From: Pagham Parish Council [REDACTED]
Sent: 25 April 2018 13:17
To: Planning.Responses
Subject: Pagham responses

Pagham Parish Council considered the following applications at a meeting of its Planning Committee held on 24th April 2018. It would comment as follows:

- 1.2 P/25/18/PL – Jenin, Nyetimber Lane, Pagham PO21 3JT - Demolition of existing garaged roof alterations to existing dwelling to provide first floor and 1No new dwelling in garden of existing dwelling **RESOLVED: The Council wishes to raise the following points:**

Peter J. Gardner Architectural Design Consultant	
	www.architecturaldesignsolutions.co.uk 07967 205249
Job Title	Jenin, Nyetimber Lane Bognor Regis PO21 3JT
Drawing Title	Proposed New Dwelling Floor Plans
Client	R.B
Date	12/05/2017
Drawn	P.J.G
Scale	1:100 on A3
Drq No.	NTL/P/01

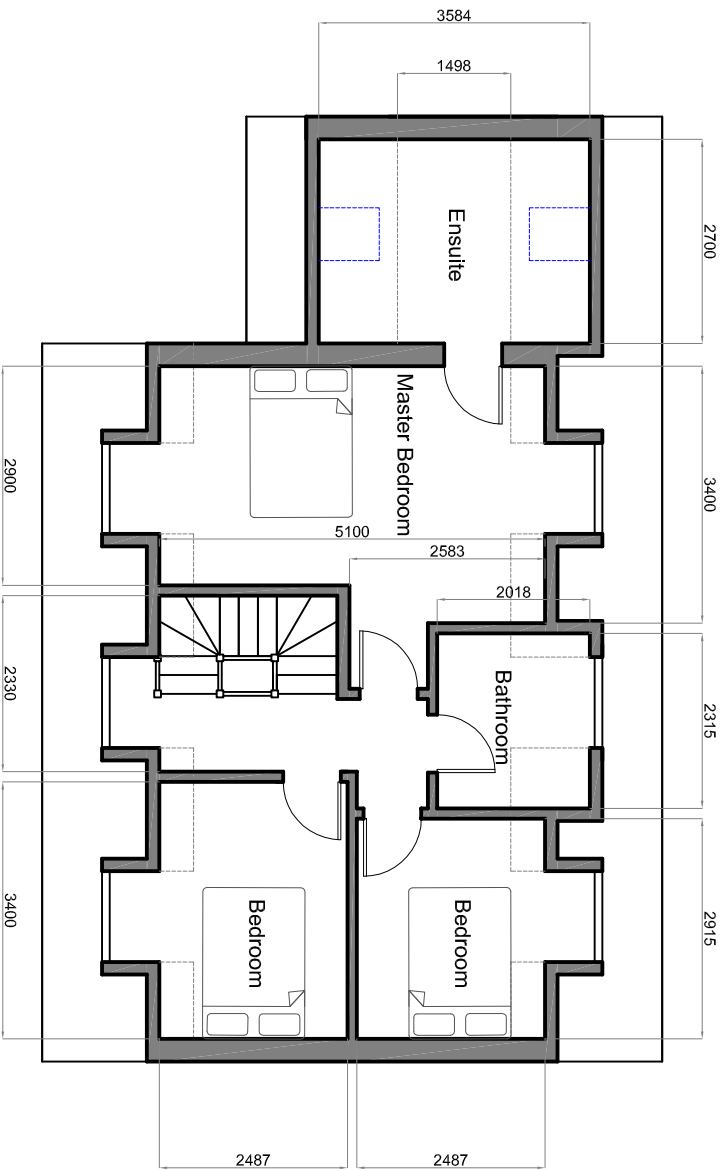
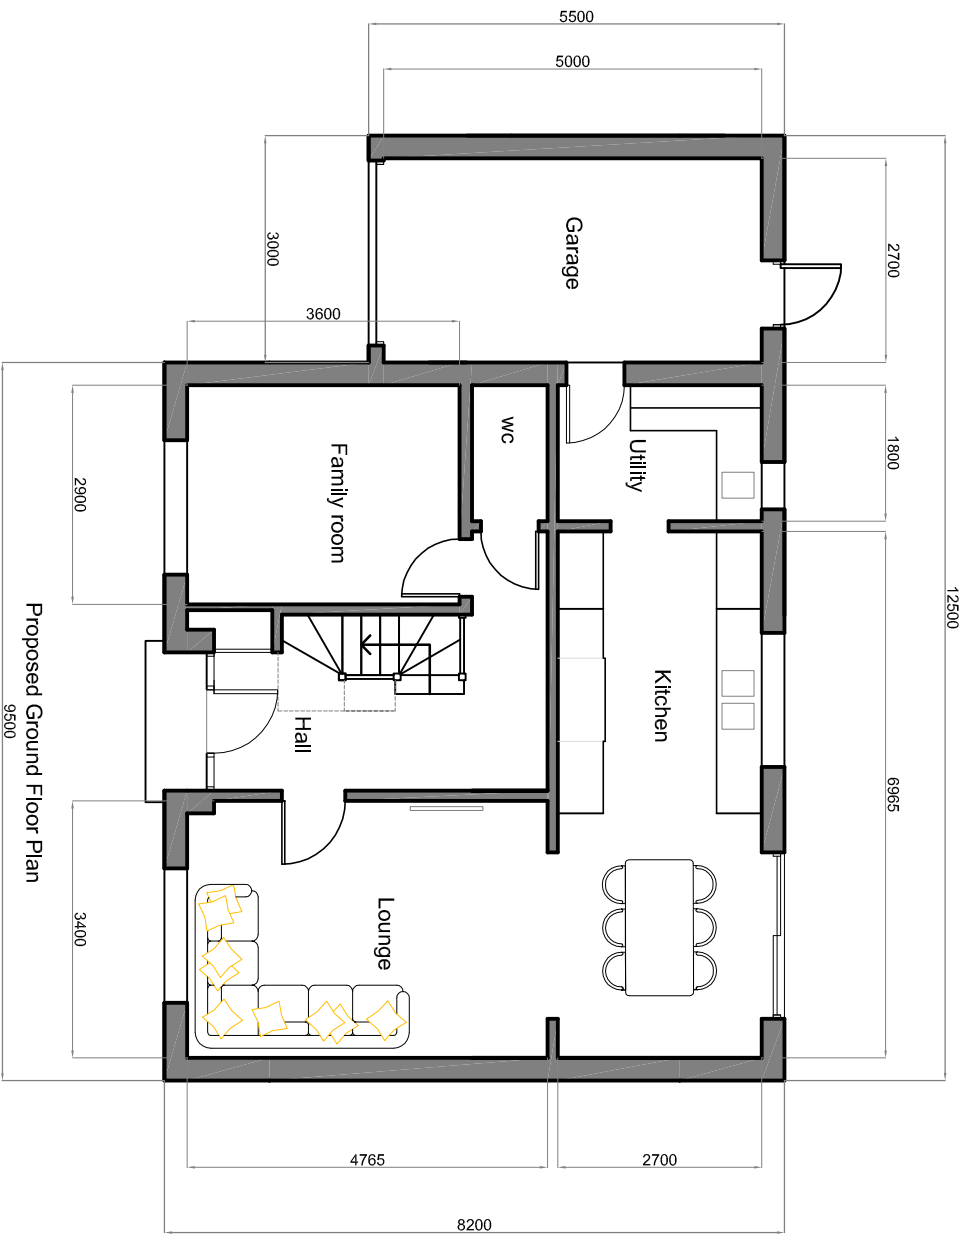
- The application would result in overdevelopment of the site. The new building is not subservient to the main building, contrary to Dev19 of the ADC Local Plan 2003 and Policy D DM1 Para 1 Character of the emerging ADC Local Plan 2011-2031.

- There are overlooking issues from both the extended existing property and new property, particularly affecting "Sports View"
- 1.3 P/26/18/PL – 6 Hook Lane Pagham PO21 3NY - Resubmission of P/86/16/PL 1No detached bungalow with on-site parking and vehicular turning facility. **RESOLVED: No objection however any potential overlooking should be mitigated. The Parish Council would wish to reiterate its comments regarding the ditch submitted for application P/86/16/PL.**

Job Title		Jenin, Nye/timber Lane Bognor Regis PO21 3JT			
Drawing Title	Block Plan Proposed				
Client	R B				
Date	12/05/2017				
Drawn	P.J.G				
Scale	1:500 on A3				
Dwg No.	NT/L/BP/02				B

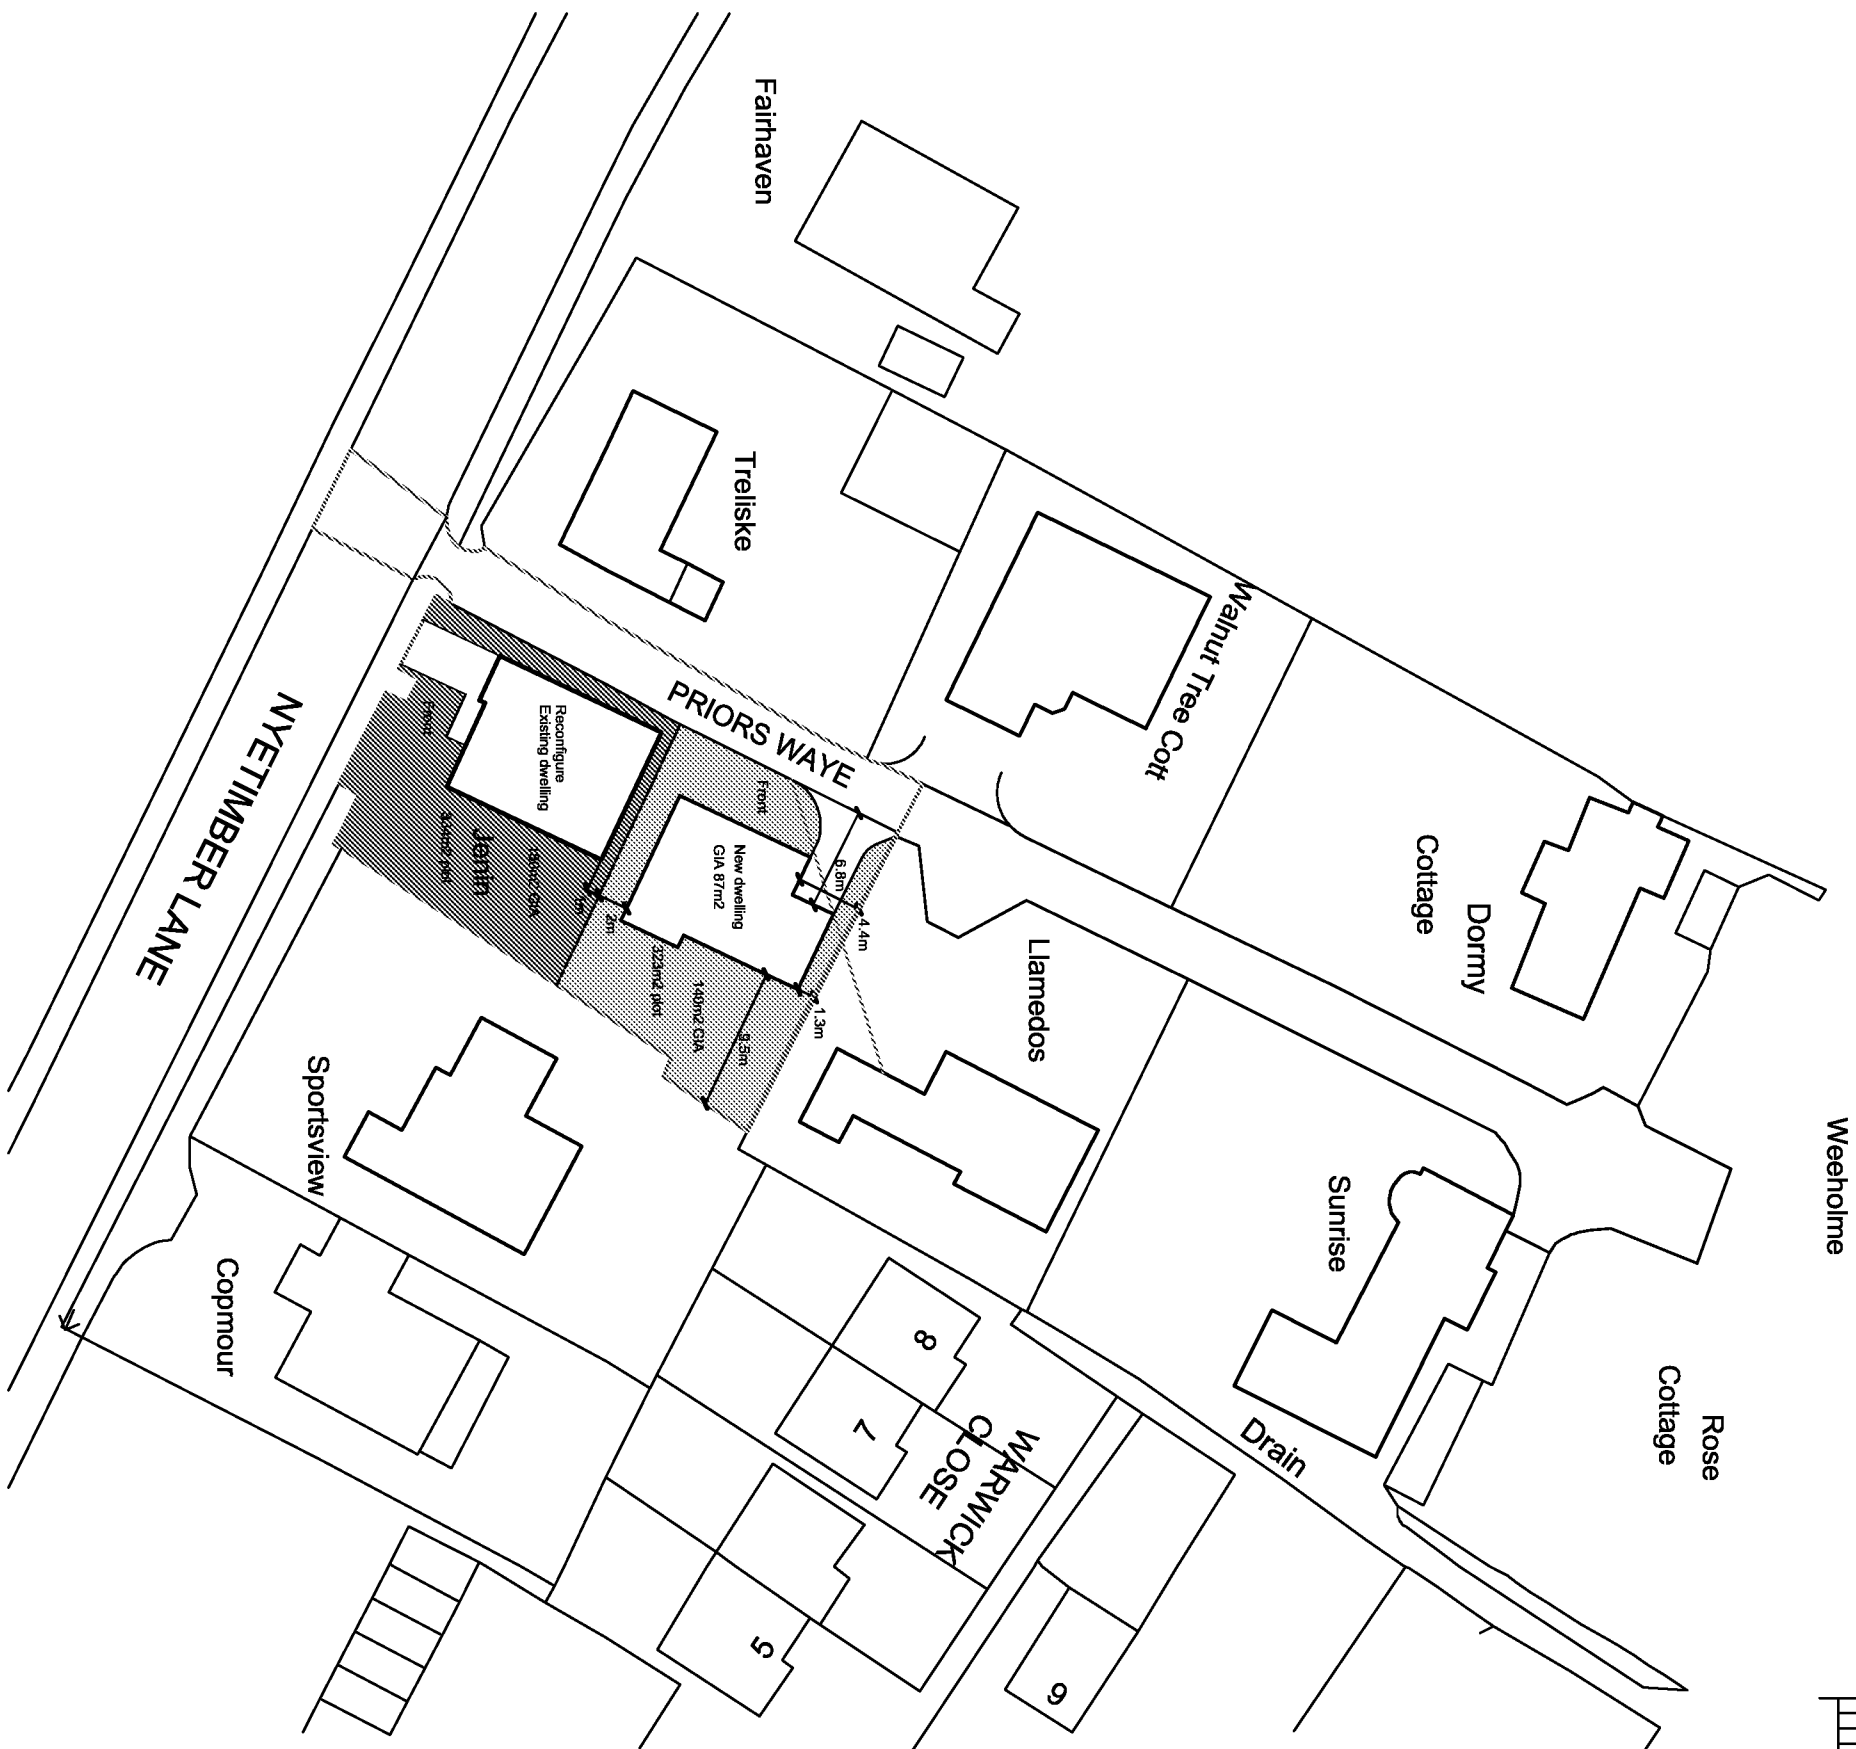
- The width of the access as described in the application may not be achievable. There is a hedge which obstructs the full 12ft which is not in the ownership or control of the applicant.
